# CITY OF ALBUQUERQUE

RE: **PresNow Uptown**  
**2100 Louisiana Blvd. NE**  
**Grading and Drainage Plan Stamp Date: 1/8/2021**  
**Drainage File: J19D055**

Based on the submittal received on 1/8/21 the above-referenced Grading and Drainage Plan is approved for Administrative Amendment.

DRAWN BY	
REVIEWED BY	
DATE	12/11/2020
PROJECT NO.	20-0161.001
DRAWING NAME	CONCEPTUAL GRADING PLAN

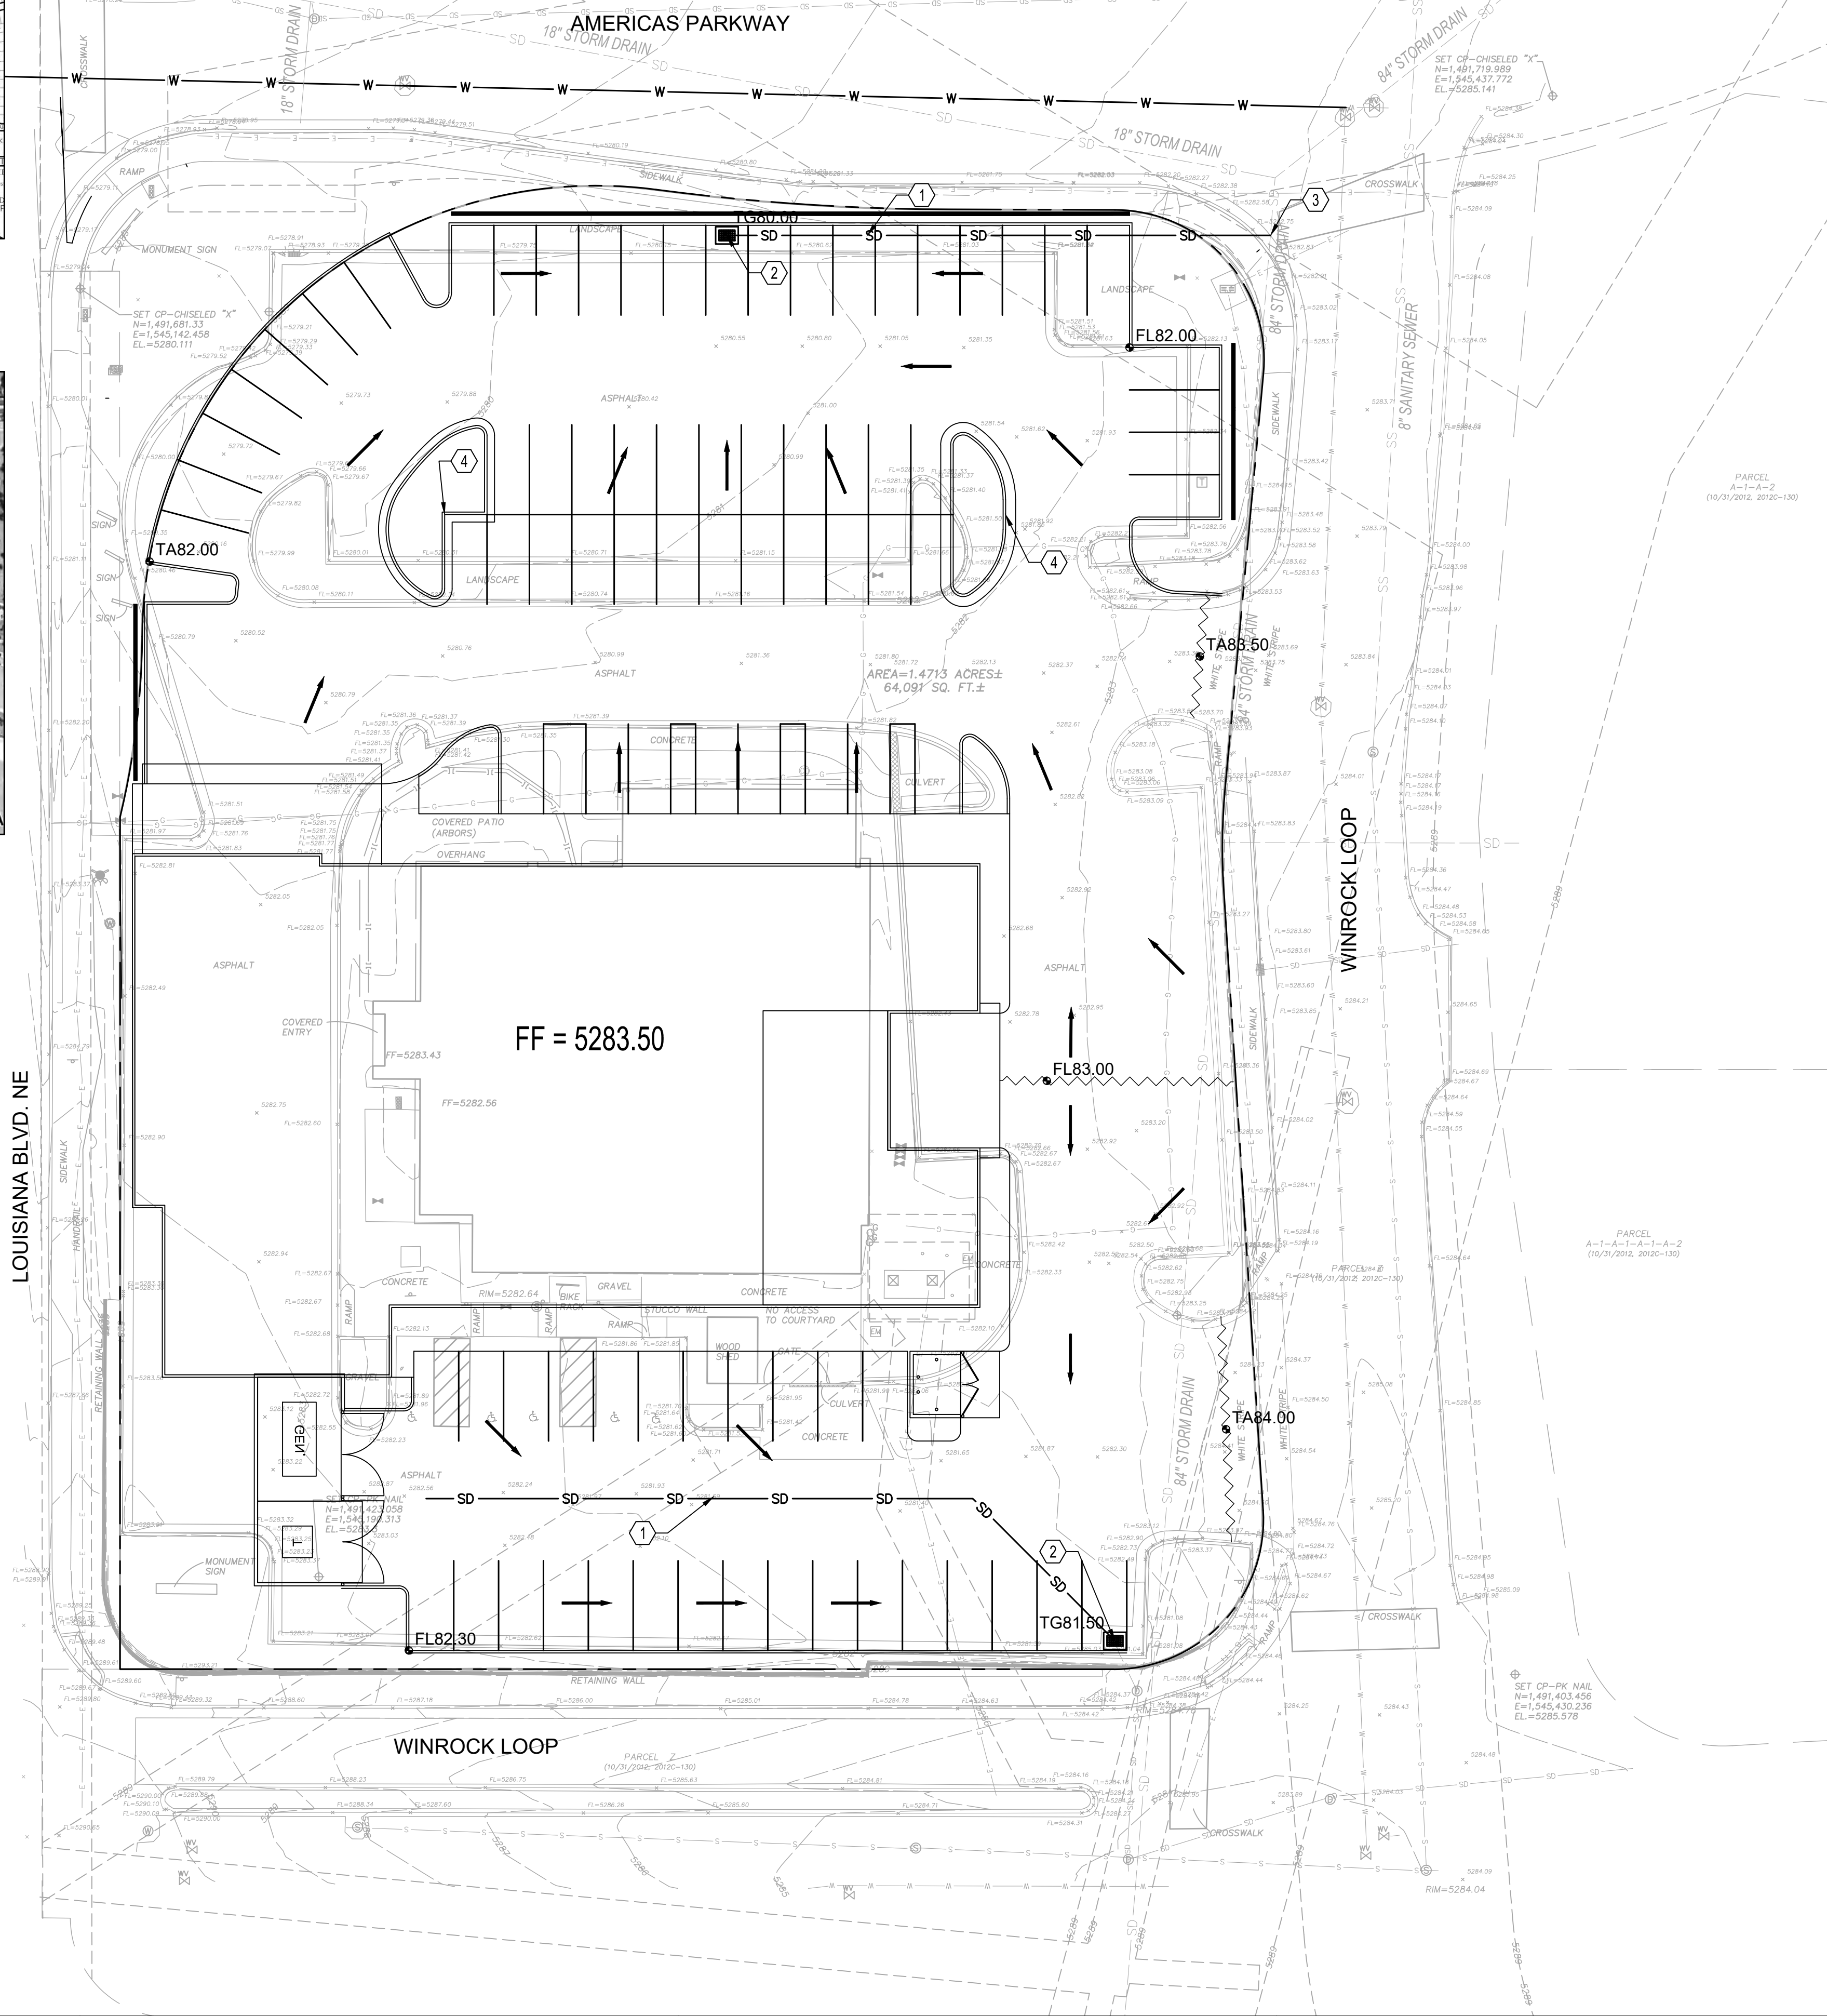
1. Please label and calculate separately the two drainage basins.
2. Show details and calculations for the new drainage inlets and new storm drain lines to show these will carry needed flows.
3. As a reminder, if the project total area of disturbance (including the staging area and any work within the adjacent Right-of-Way) is 1 acre or more, then an Erosion and Sediment Control (ESC) Plan and Owner's certified Notice of Intent (NOI) is required to be submitted to the Stormwater Quality Engineer (Doug Hughes, PE, [jhughes@cabq.gov](mailto:jhughes@cabq.gov), 924-3420) 14 days prior to any earth disturbance.
